Charlotte Department of Transportation

Memorandum

Subject: Rezoning Petition 08-093: Located at the intersection of Lancaster Highway and Johnston Road

01 TECHNICAL DATA SHEET

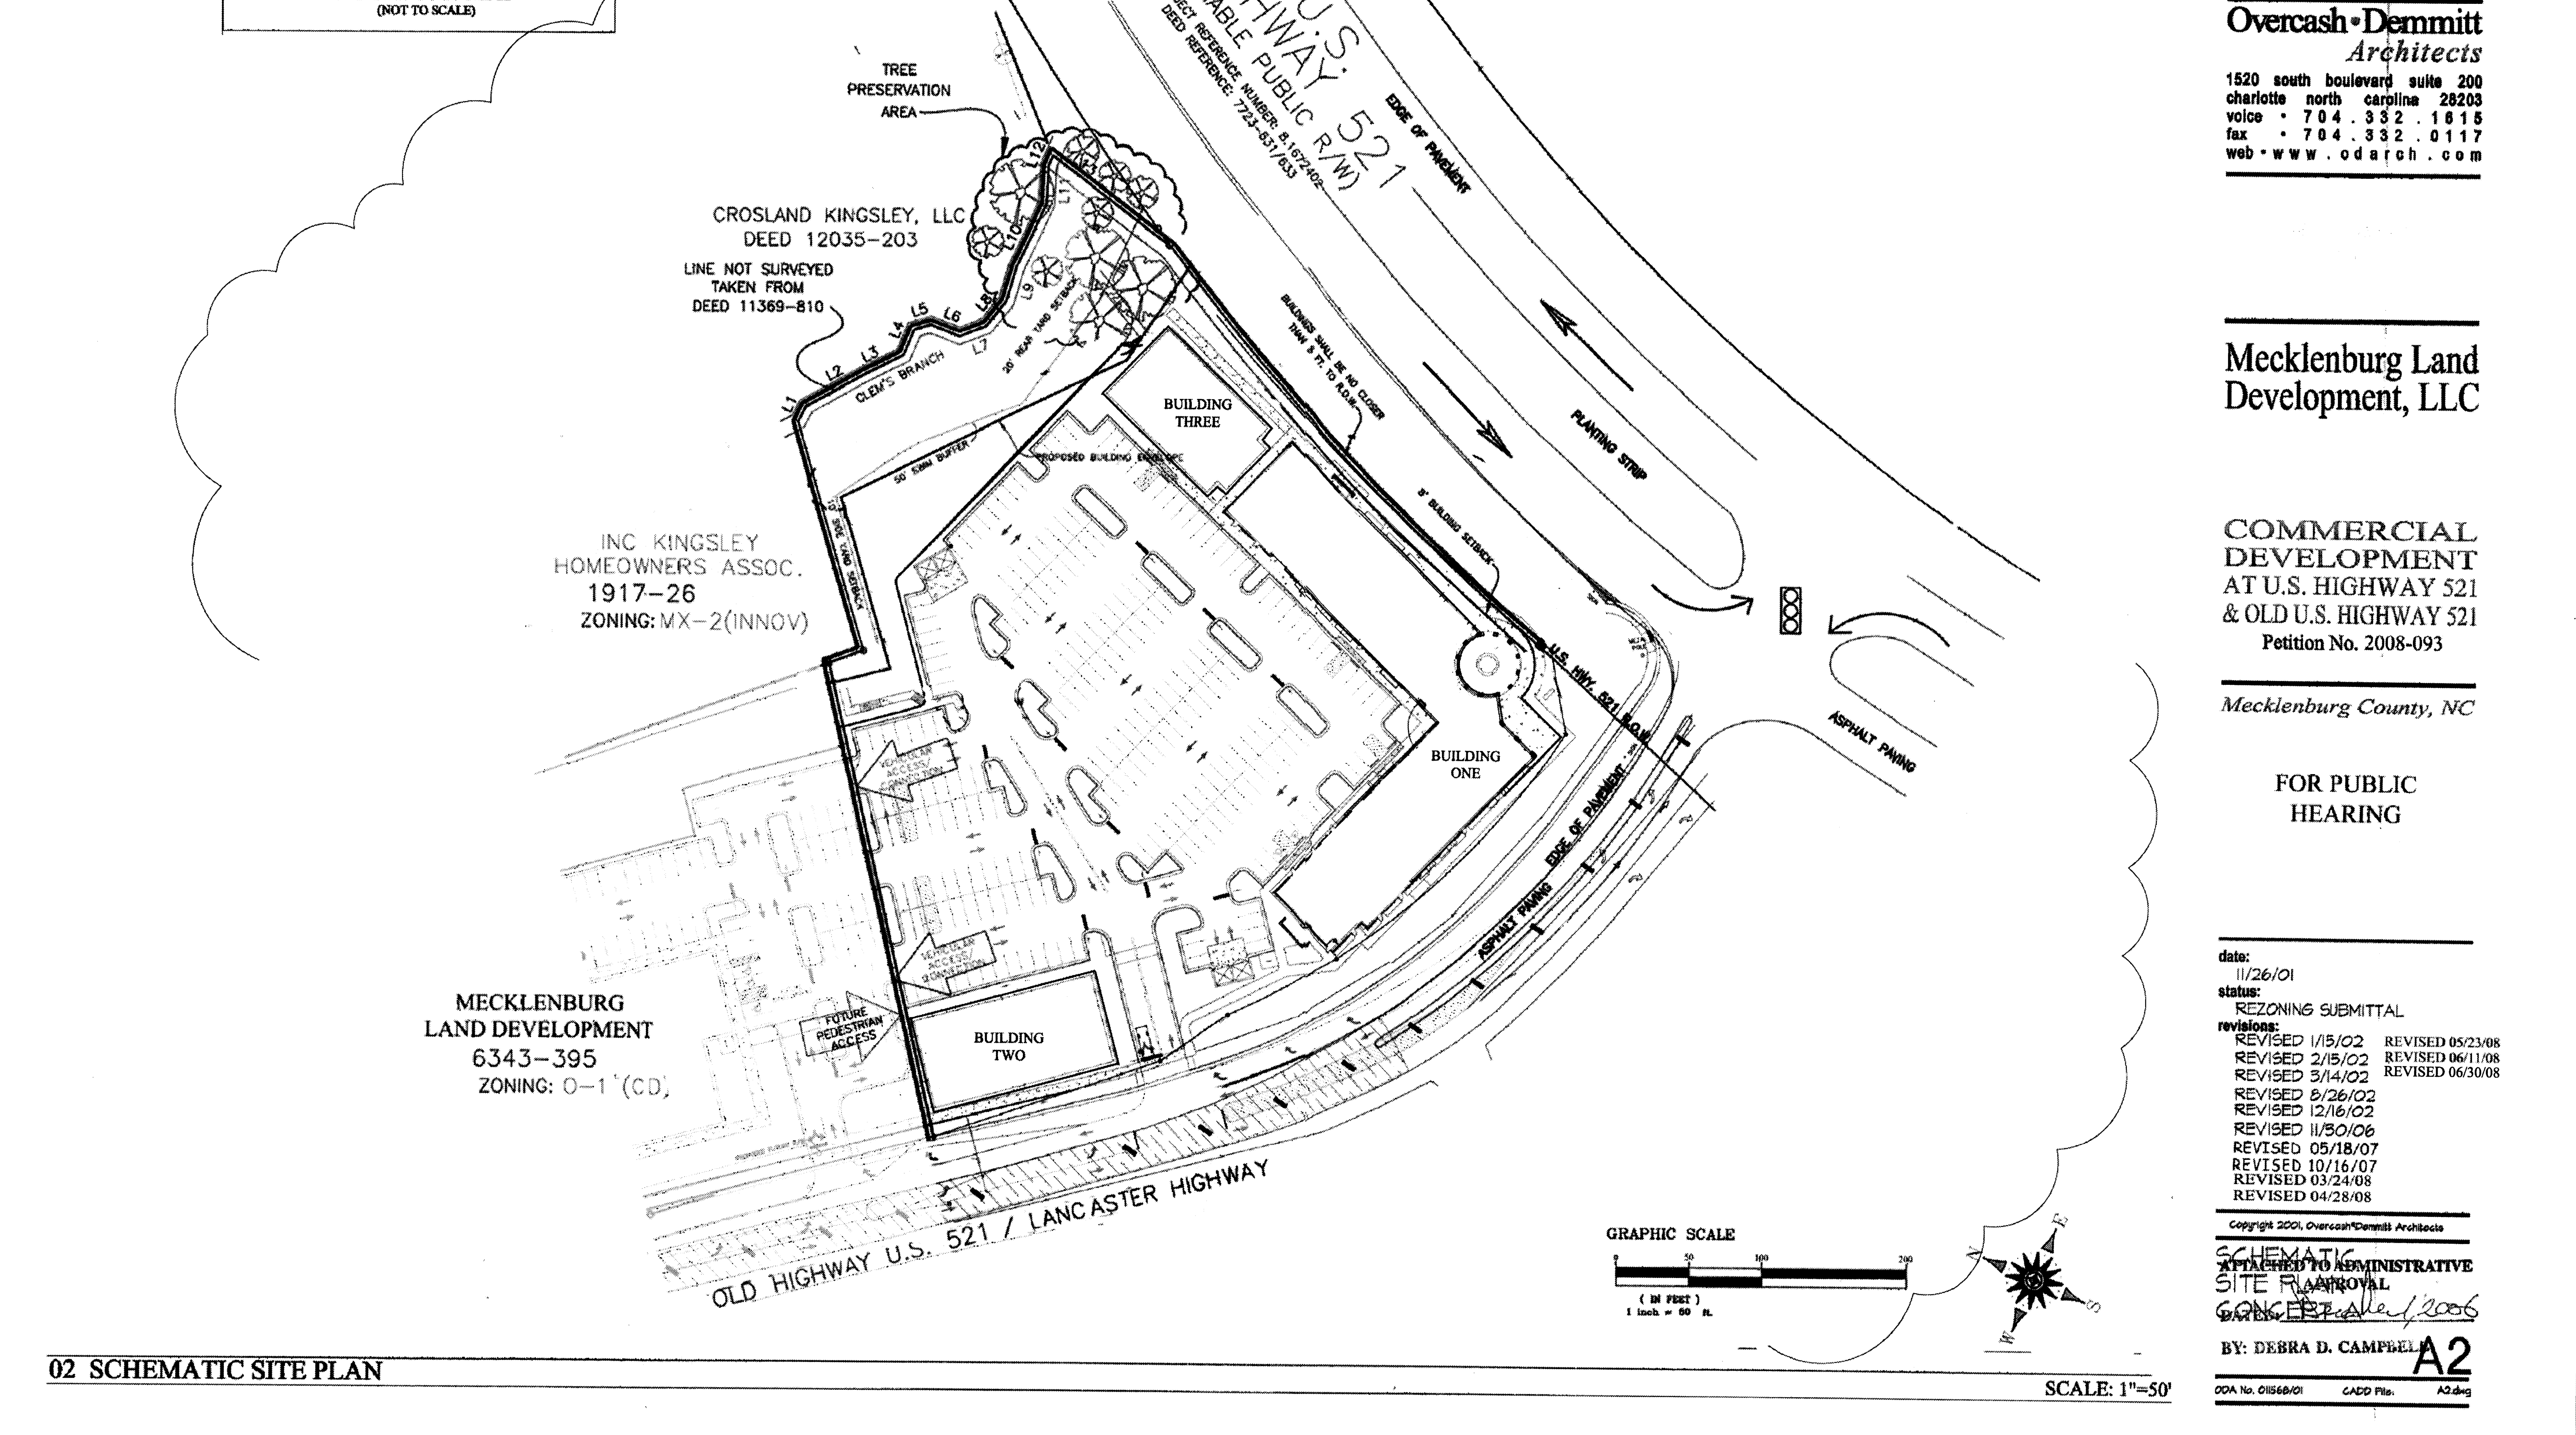
1. Public street sidewalks (whether in the right-of-way or on private property on an easement) must be ADA compliant. Steps will not be allowed in the right-of-way. Steps will be allowed in an easement provided that there is a corresponding accessible ramp adjacent to the steps.
2. Sidewalks (external to the development) must be provided along the entire length of all public streets. However, the developer may locate and meander the sidewalk beyond the standard 8' planting strip in order to preserve existing trees. The note concerning the termination of sidewalk at the tree save area needs to be deleted.

Highway 521 is a Parkway requiring a minimum of 200 feet of right-of-way. Lancaster Highway is a Boulevard requiring 120 feet of right-of-way. The stub (remnant) of Lancaster Highway is an Office/Commercial Narrow street requiring a minimum of 60 feet of right-of-way. The developer/petitioner should convey right-of-way in fee simple title to meet these requirements, measuring 100, 60, and 30 feet from the centerlines of the respective roadways.

Adequate sight triangles must be reserved at the existing/proposed street entrance(s). Two 35' x 35' and two 10' x 70' sight triangles are required for the entrance(s) to meet requirements. All proposed trees, berms, walls, fences, and/or identification signs must not interfere with sight distance at the entrance(s). Such items should be identified on the site plan.

- Dimension width of the existing and proposed driveways.
- New/reconstructed driveways must be drop curb ramp Type II driveways.
- Indicate the locations and widths of all adjacent and opposing driveways.

- Indicate typical parking module dimensions.
- Include a parking summary with figures for the numbers of parking spaces required and provided.
